DEVELOPMENT HEARING OFFICER (DHO)

PR-2021-005864

SD-2023-00219 – PRELIMINARY/FINAL PLAT

REQUEST: REQUEST PRELIMINARY/FINAL PLAT REVIEW TO CREATE TWO NEW TRACTS FROM EXISTING TRACT F

Section A-A; Proposed 98th Street Cross Section Looking North
NTS

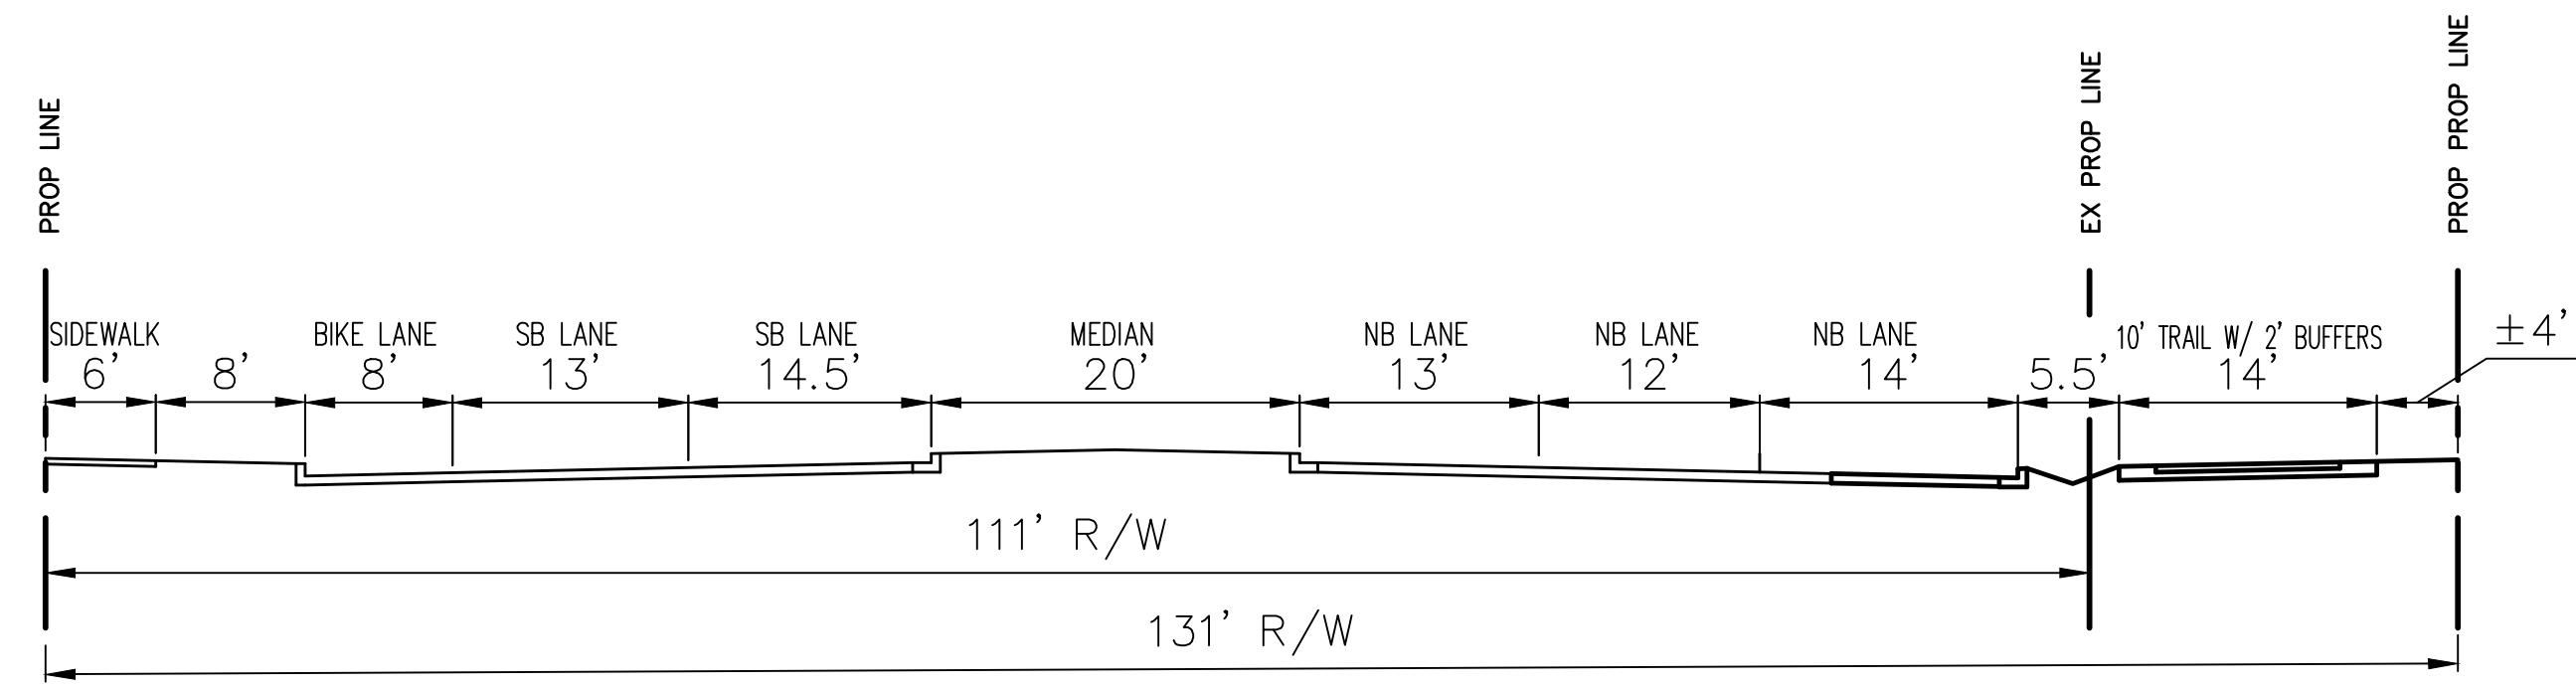
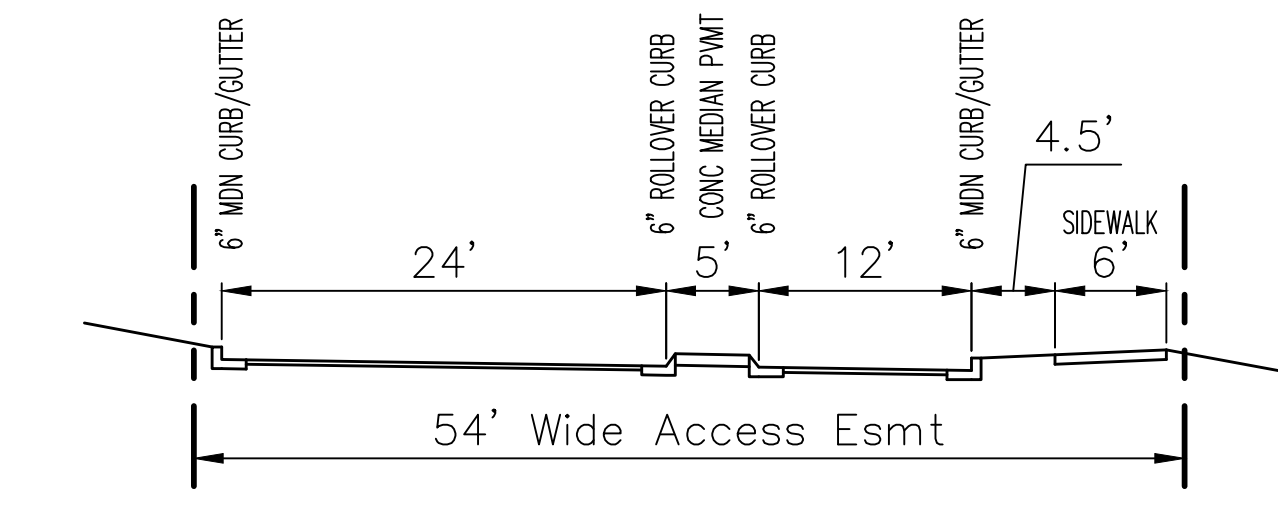
- 5.3.D.1 Confirm that perimeter sidewalks will be built according to DPM Reference DPM 7.2.29 for Sidewalk/landscape buffer widths.
The approved infrastructure list indicated a 6-foot sidewalk on Bluewater and 98th Streets. **Confirm that a 4-6-foot landscaped buffer is between the curb and the sidewalk.**

Section E-E; Proposed 30' Wide Private Road
NTS

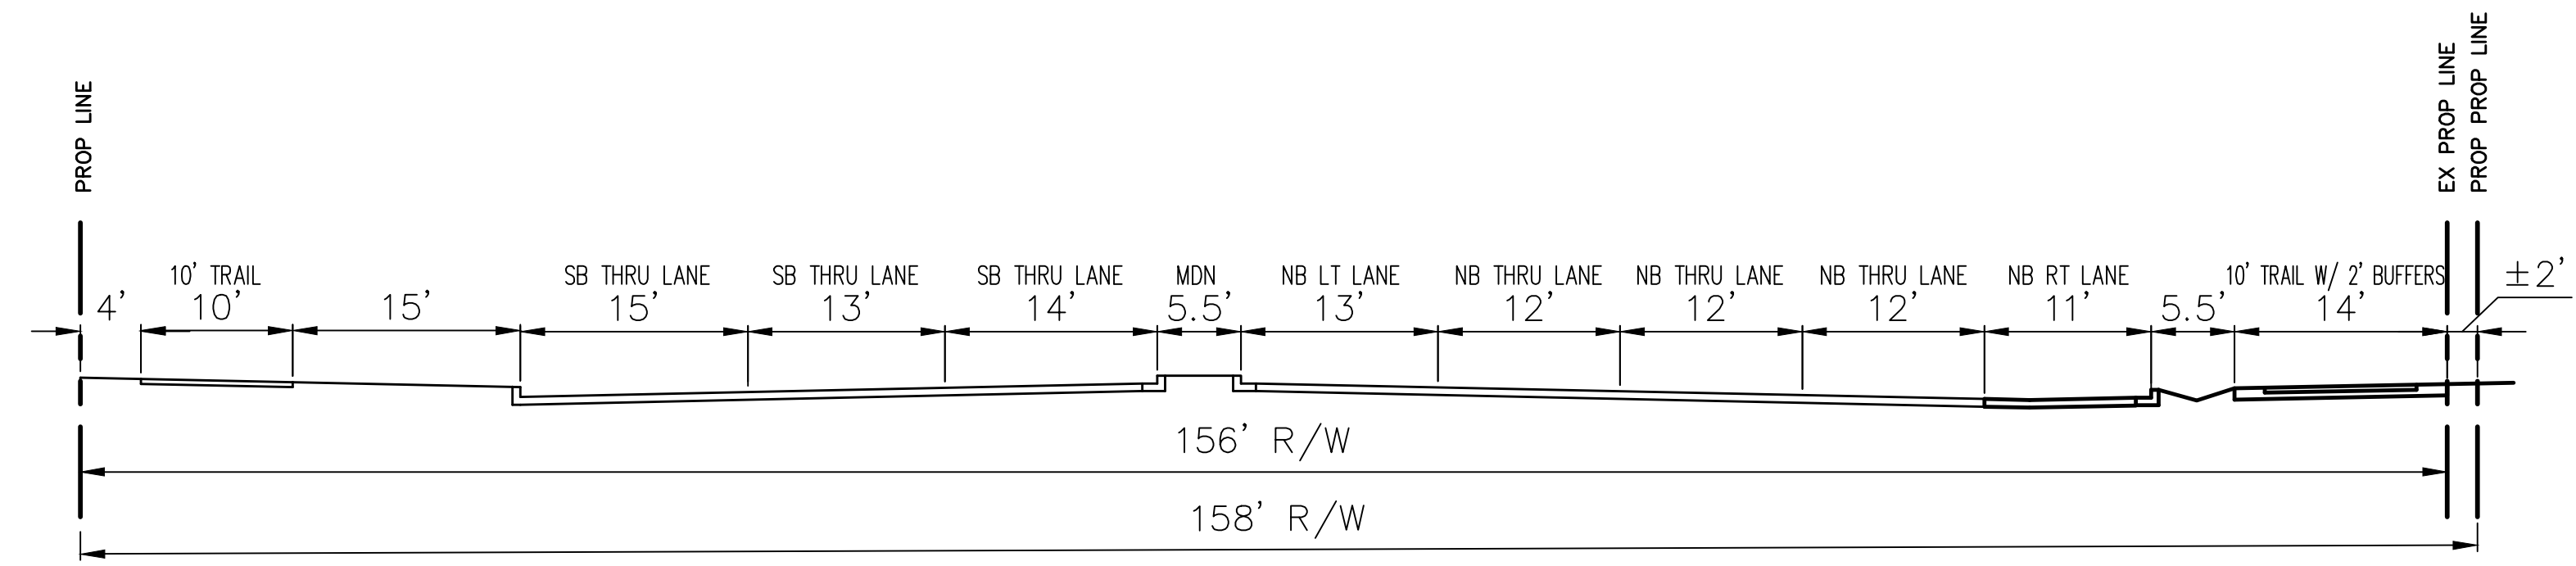
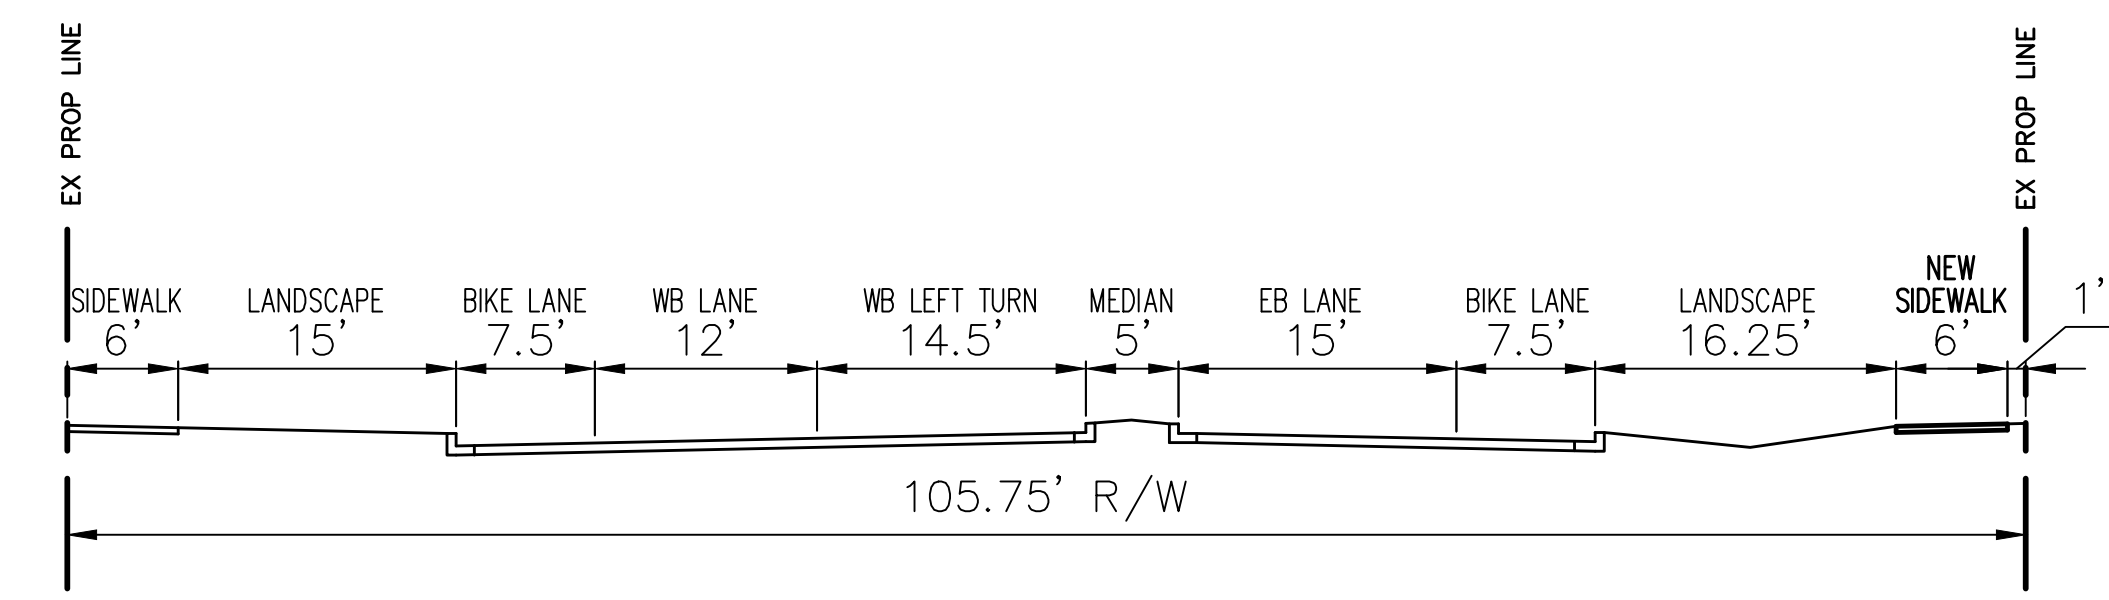
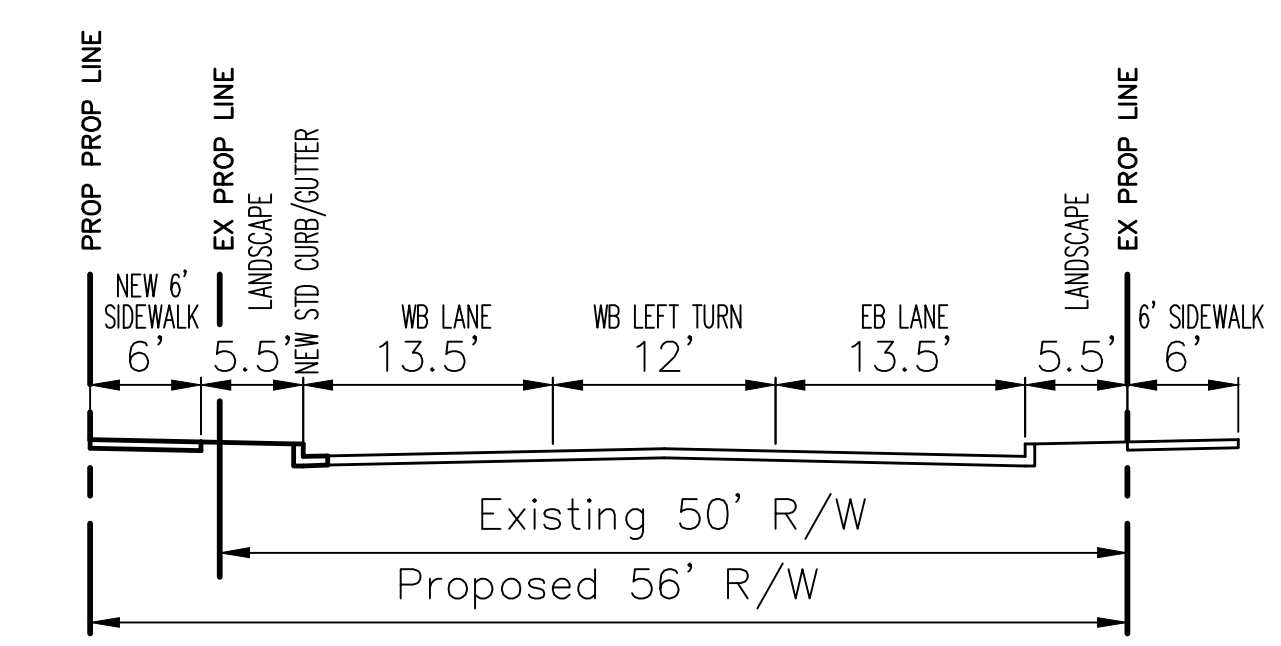
1. Transportation has an approved TIS dated 8/23/2022. No objection
2. Please note that an approved TCL will be required prior to site plan approval. The plans you have included do not show any internal sidewalks along the private roads. A minimum 5' sidewalk will be required along these roads to provide pedestrian access to individual buildings within the development.
